From: Derek Richardson <derek.richardson@tameside.gov.uk>
Sent: 17 July 2025 14:47
To: Planning
Subject: App 3/2025/0359 Erection of a cattle finishing building, Cunliffe House Farm Longsight Road Langho - Ecology Unit Response

App 3/2025/0359 Erection of a cattle finishing building, Cunliffe House Farm Longsight Road Langho

**Proposal Plan**

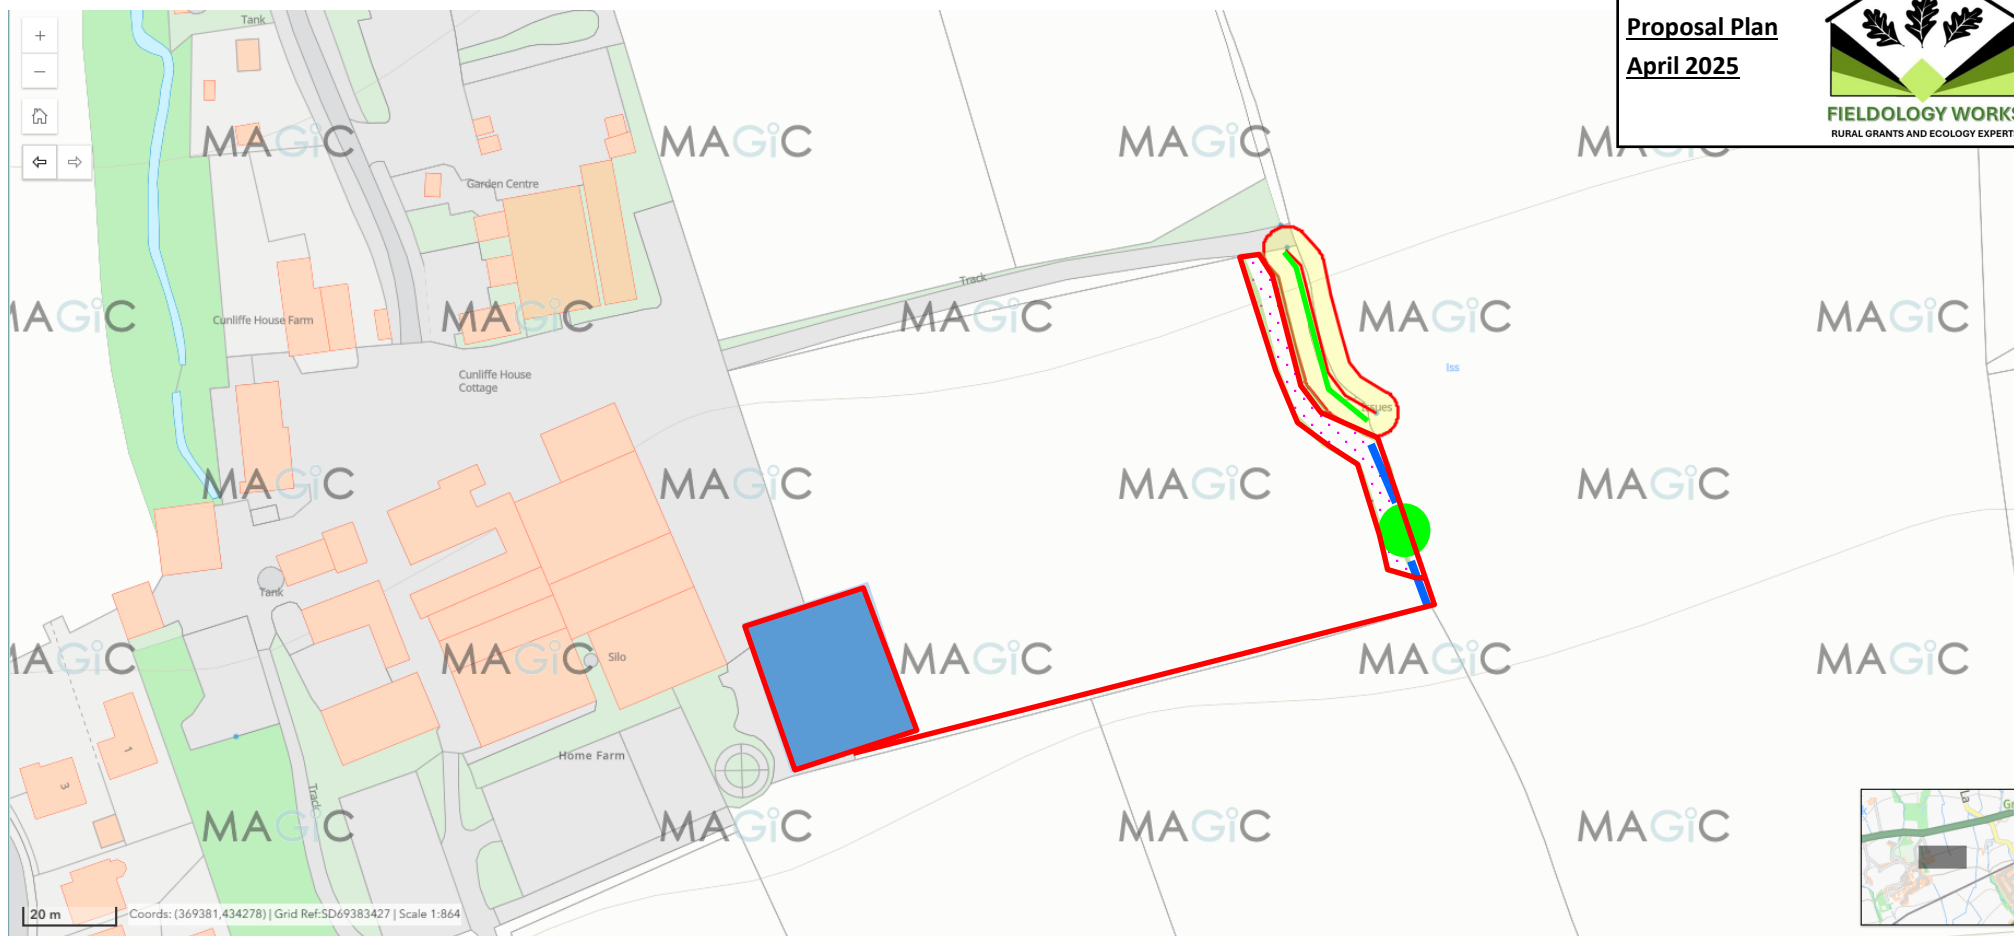
I would accept that the proposals could achieve an overall net gain in Biodiversity of at least 10% through the enhancement of grassland and hedgerows on the wider landholding. While I would not regard the on-site habitat enhancements to be significant, and therefore I would not advise that a 30-year Habitat Management and Monitoring Plan is required, nevertheless a habitat and landscape establishment and management plan should still be required by Condition. I note that some management proposals have been provided as part of the current application, these proposals could be expanded and included in the LEMP.

Proposed Building

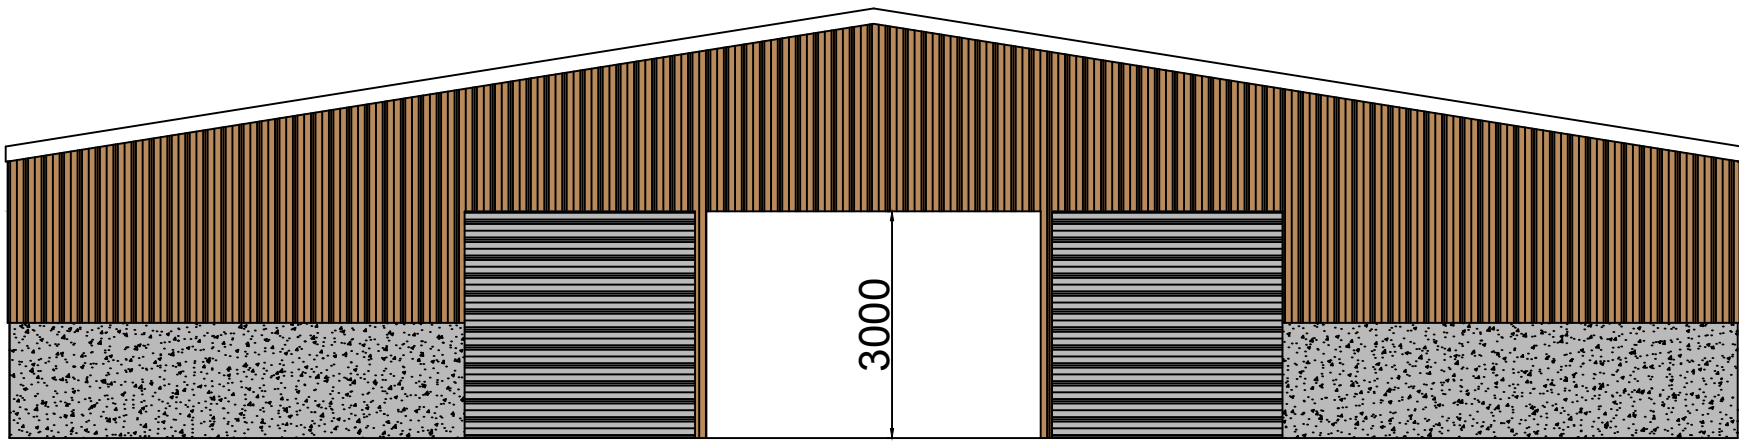
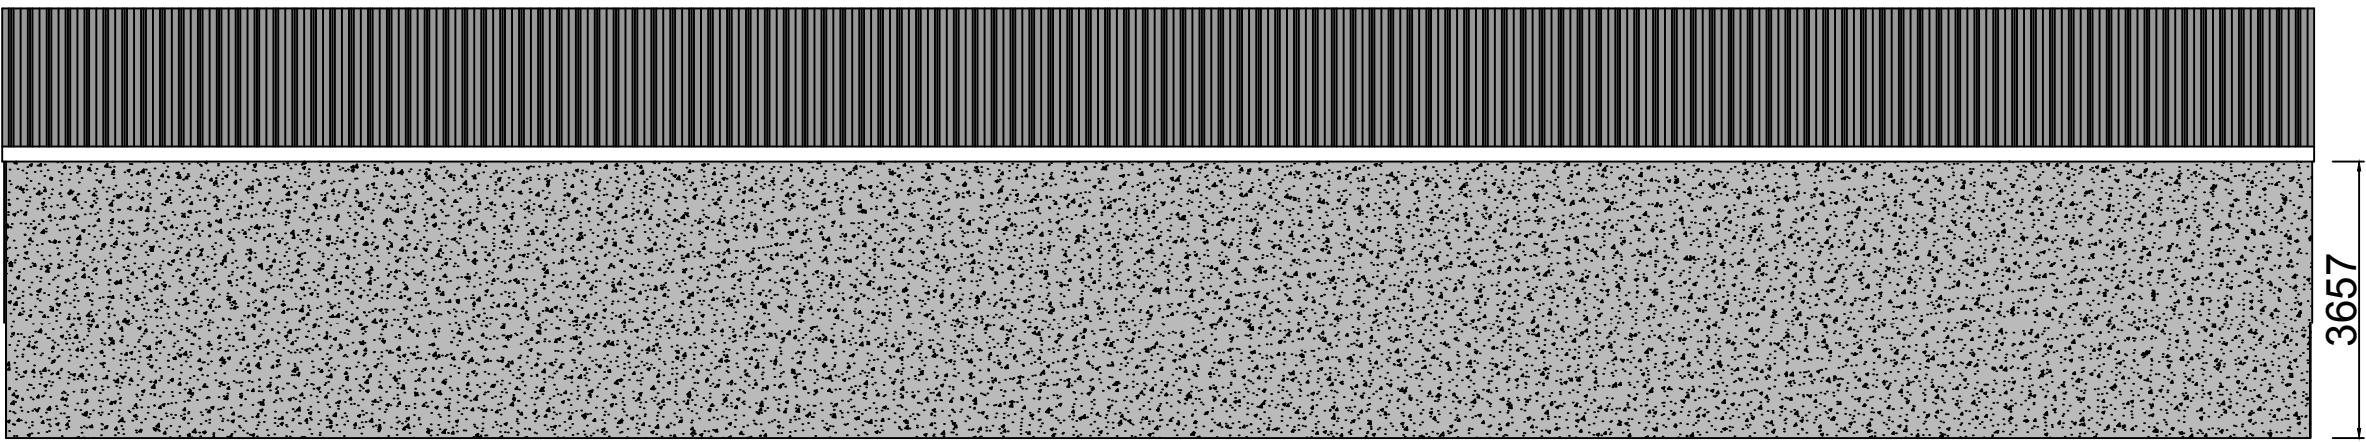
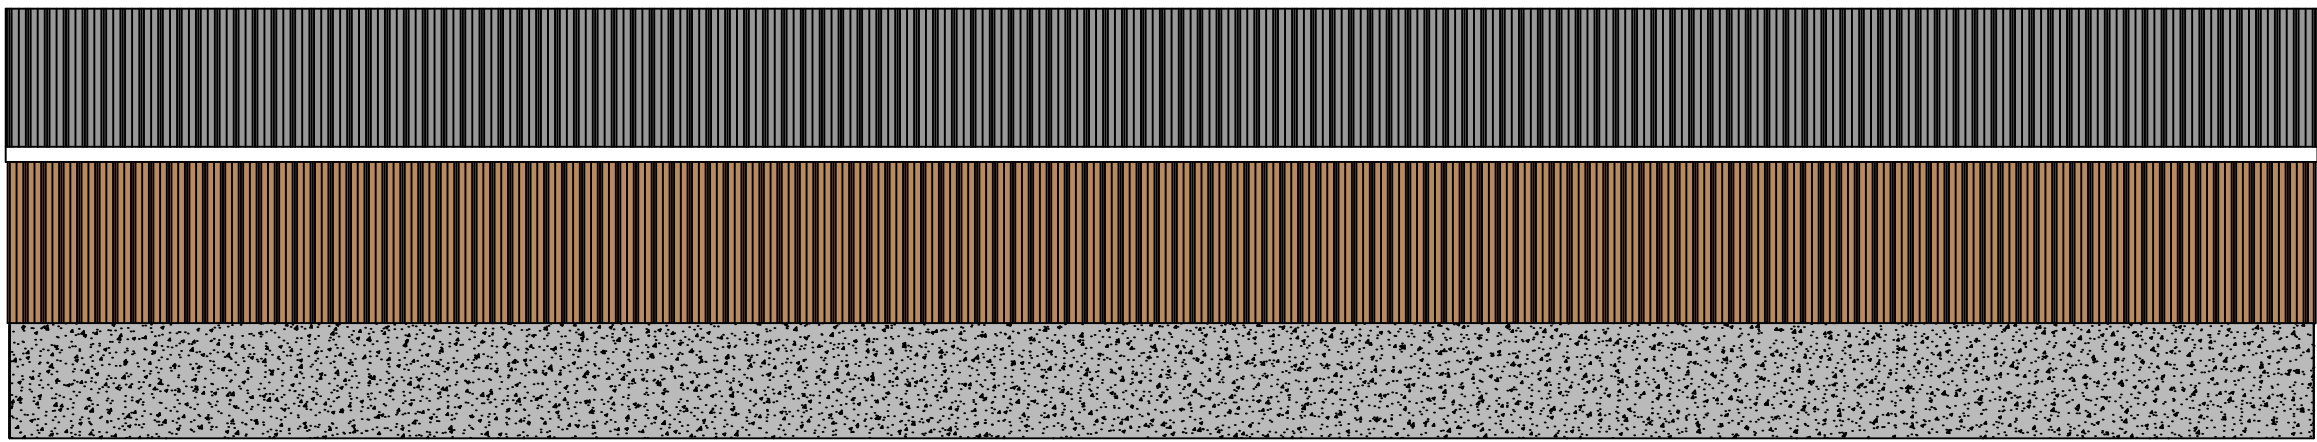
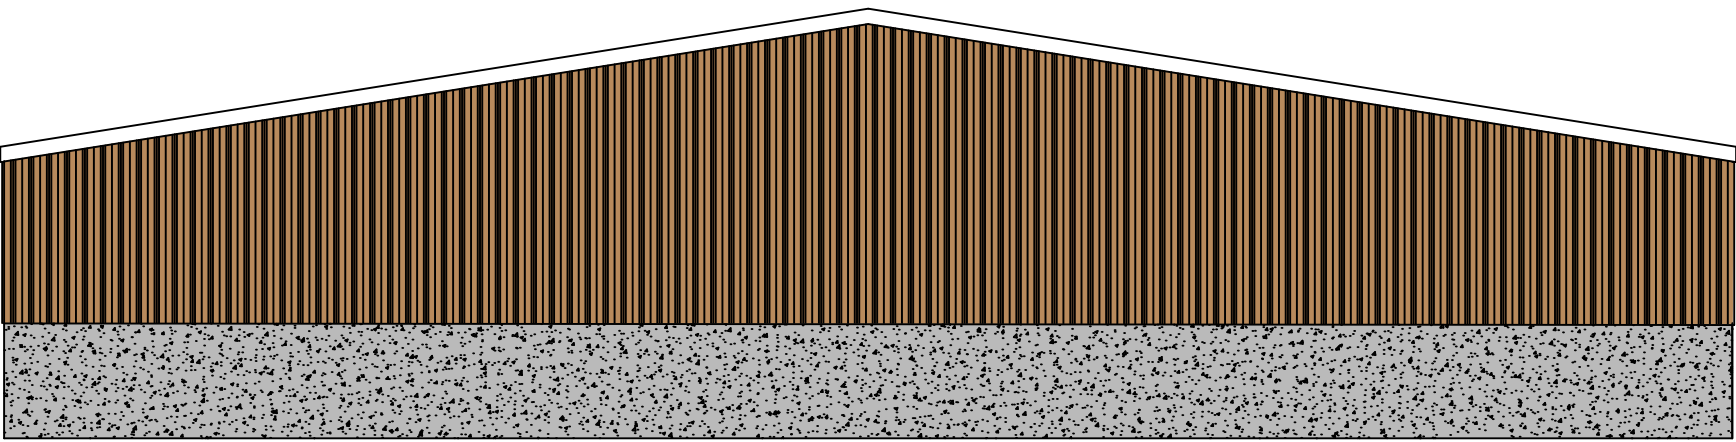
The development would also benefit from the installation of 2 no. bird nesting boxes on the new building, once complete.
